**From:** Lucy Harding  
**Sent:** 20 March 2017 10:15  
**To:** Planning.Responses  
**Subject:** FW: Land north of Bonhams, Yapton - Y/1/17/OUT

**ADC Planning Consultation  
Response from the Historic Buildings Adviser**

| <b>Application Number</b> | Y/1/17/OUT                                                                                                                                                                                                                                                                             |
| <b>Description</b>        | Outline Application with some matters reserved for the erection of 56 No. dwellings with associated open space and creation of new access. This application is a Departure from the Development plan & affects the character & appearance of the Yapton (Main Road) Conservation Area. |

Appendix B: Proposed Master Plan

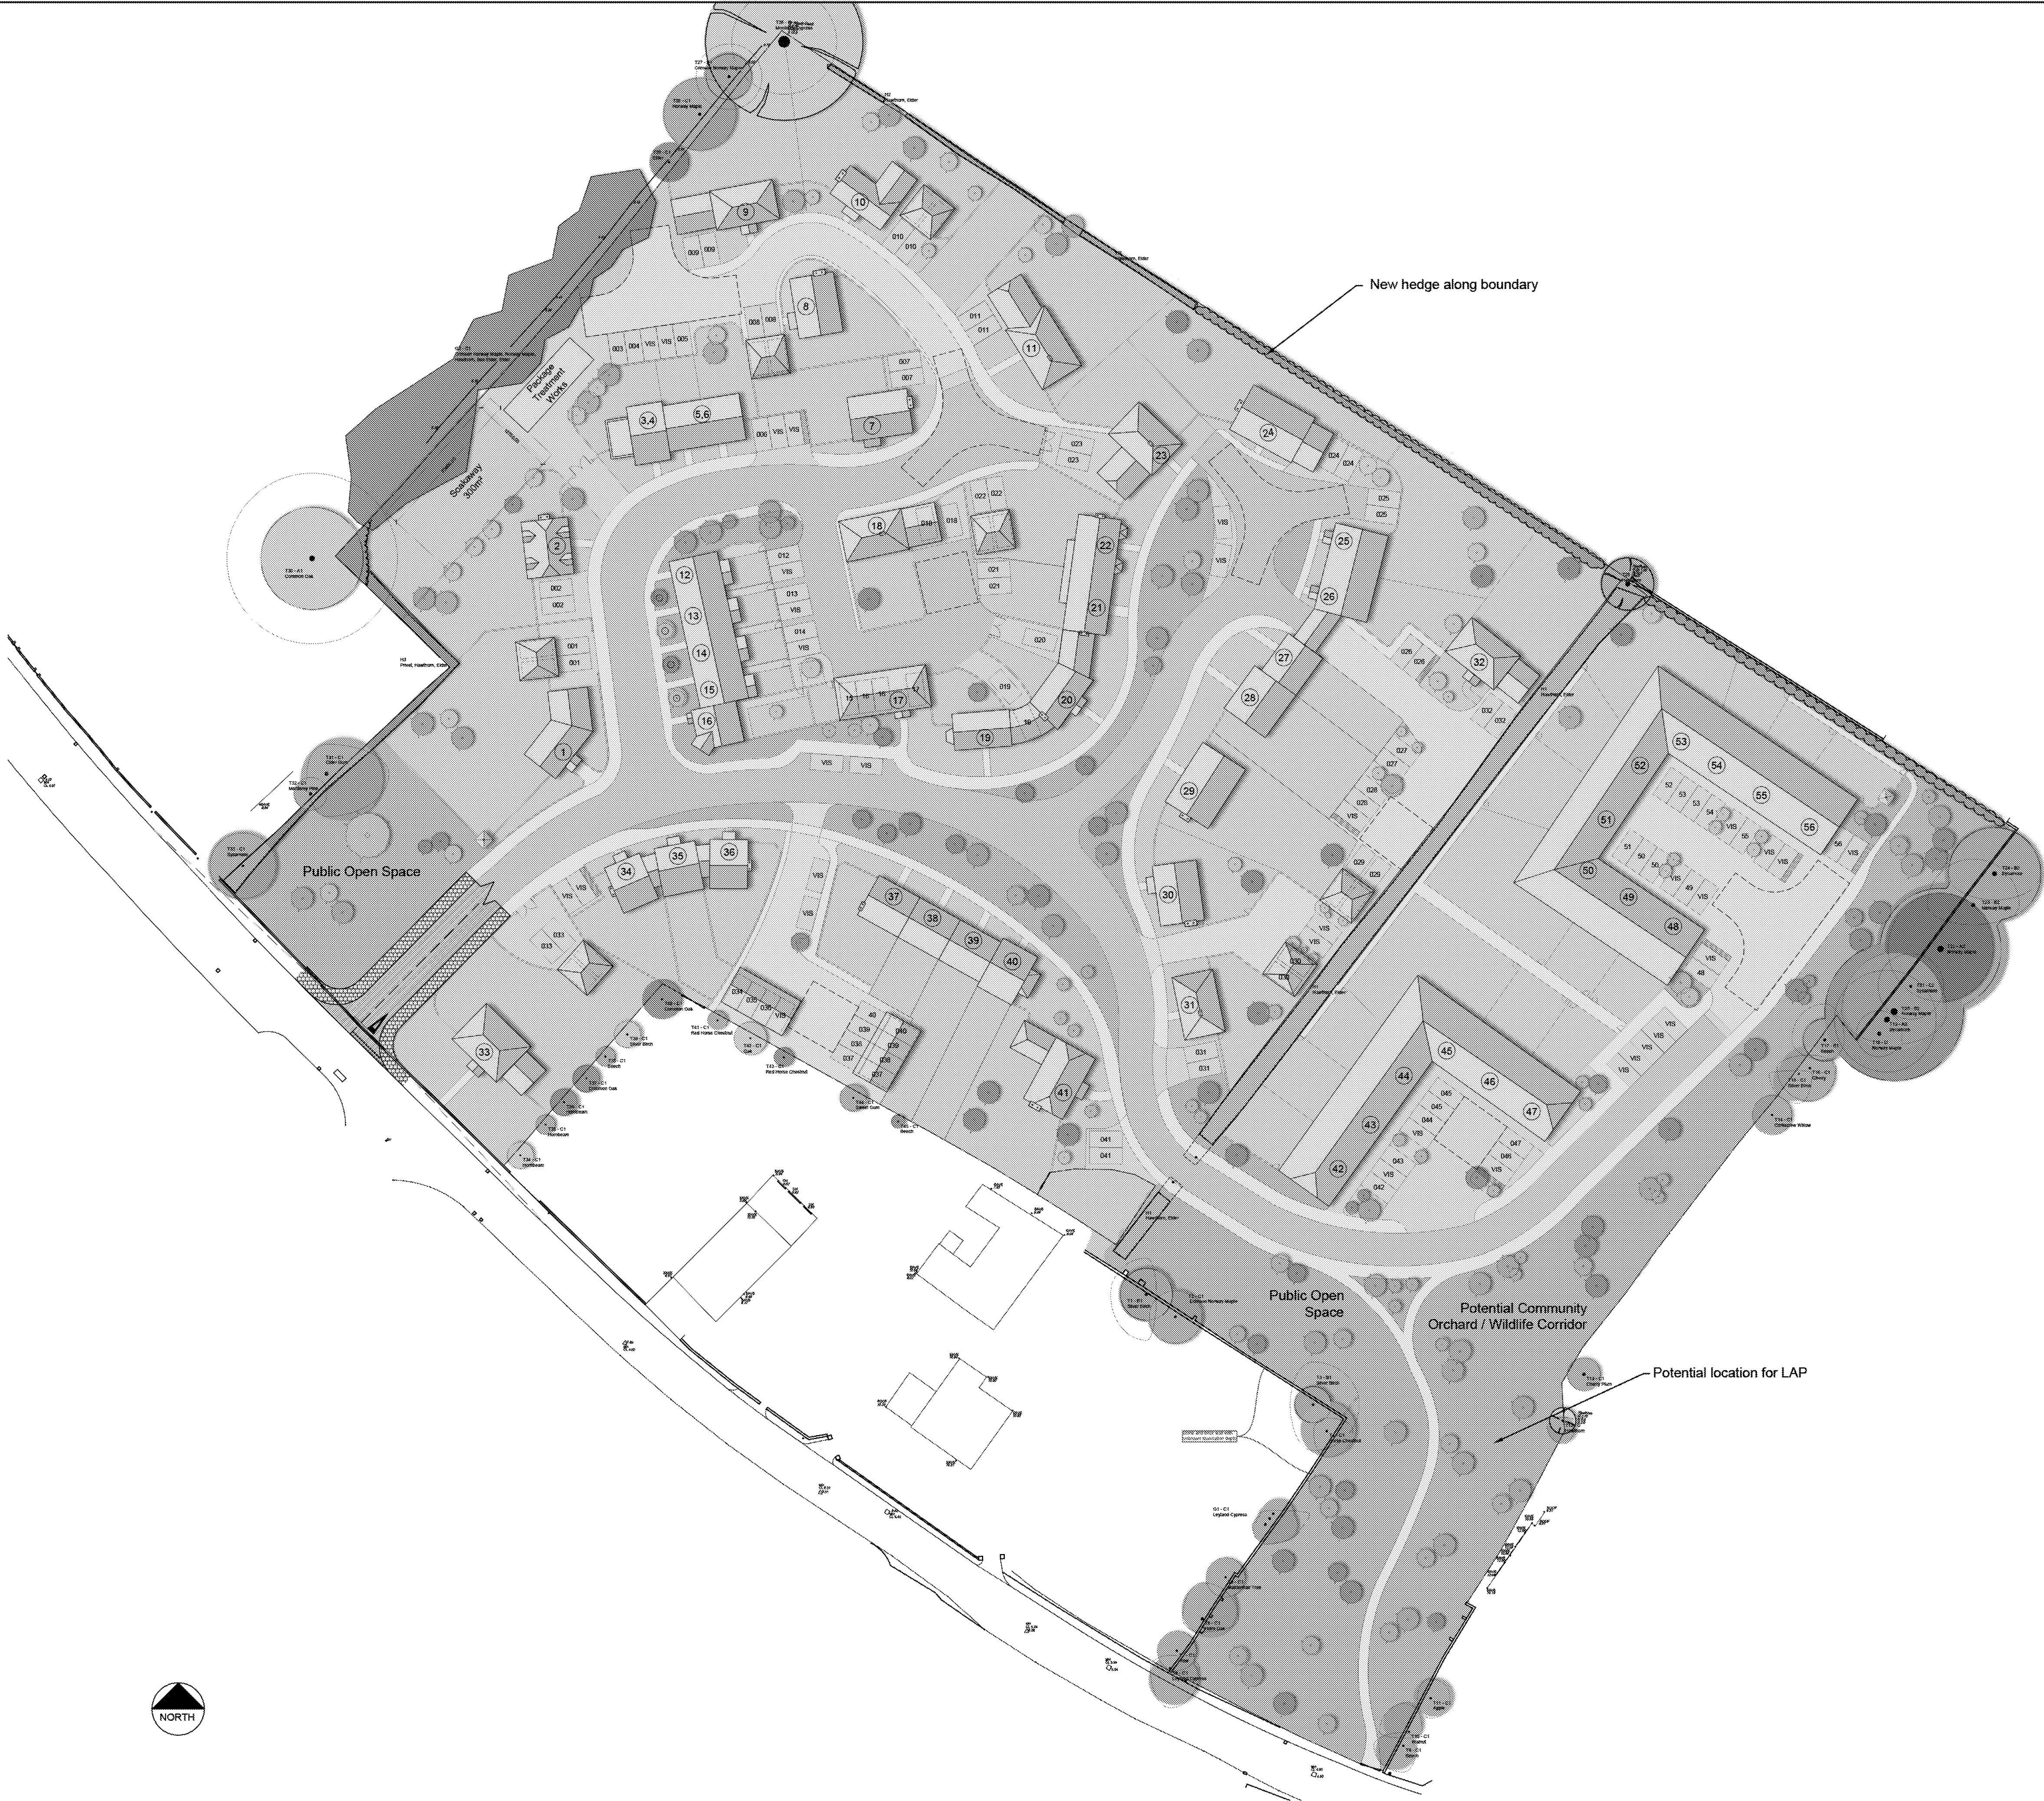
The entrance to the site has one house proposed on the corner and then open space and low level buildings before the development increases in scale and density. Given that there is a strand of development along the main road, the integration of the development into the existing built form and historic grain could be better expressed here.

The retention of open land to the east of Bonhams is positive and the approach of creating two barn-like developments beyond is preferable to two storey housing. Where this approach suffers is in the orientation of the 'barns'. The southern barn should be rotated so that parked cars are concealed from views northwards. This part of the scheme would also benefit from access being created further north so that cars and their headlights are less visible leaving the site. The gardens should also be reconsidered to mitigate the potential suburban effect.

The main house designs will also need to be more restrained in parts than as shown. The scheme would benefit in places from well-designed terraces which provide a level of understated consistency. It is suggested that the range of materials, heights and styles will make the scheme 'vibrant and varied', however given the site's semi-rural character, this may not be completely appropriate. The visualization provided, which whilst likely to be schematic, shows dwellings changing in height, form and appearance at every opportunity which is not always necessary or convincing as a means for creating a sense of natural growth.

At present, the design, scale and layout of the buildings appears mindful of a Poundbury-type development, though unlike Dorchester, the extension here is to a village and not a town. There is not the density in the existing setting to support such an approach and so if the principle of development was found to be acceptable, further consideration should be given to mitigating potential harm through layout and design and better integrating the scheme.
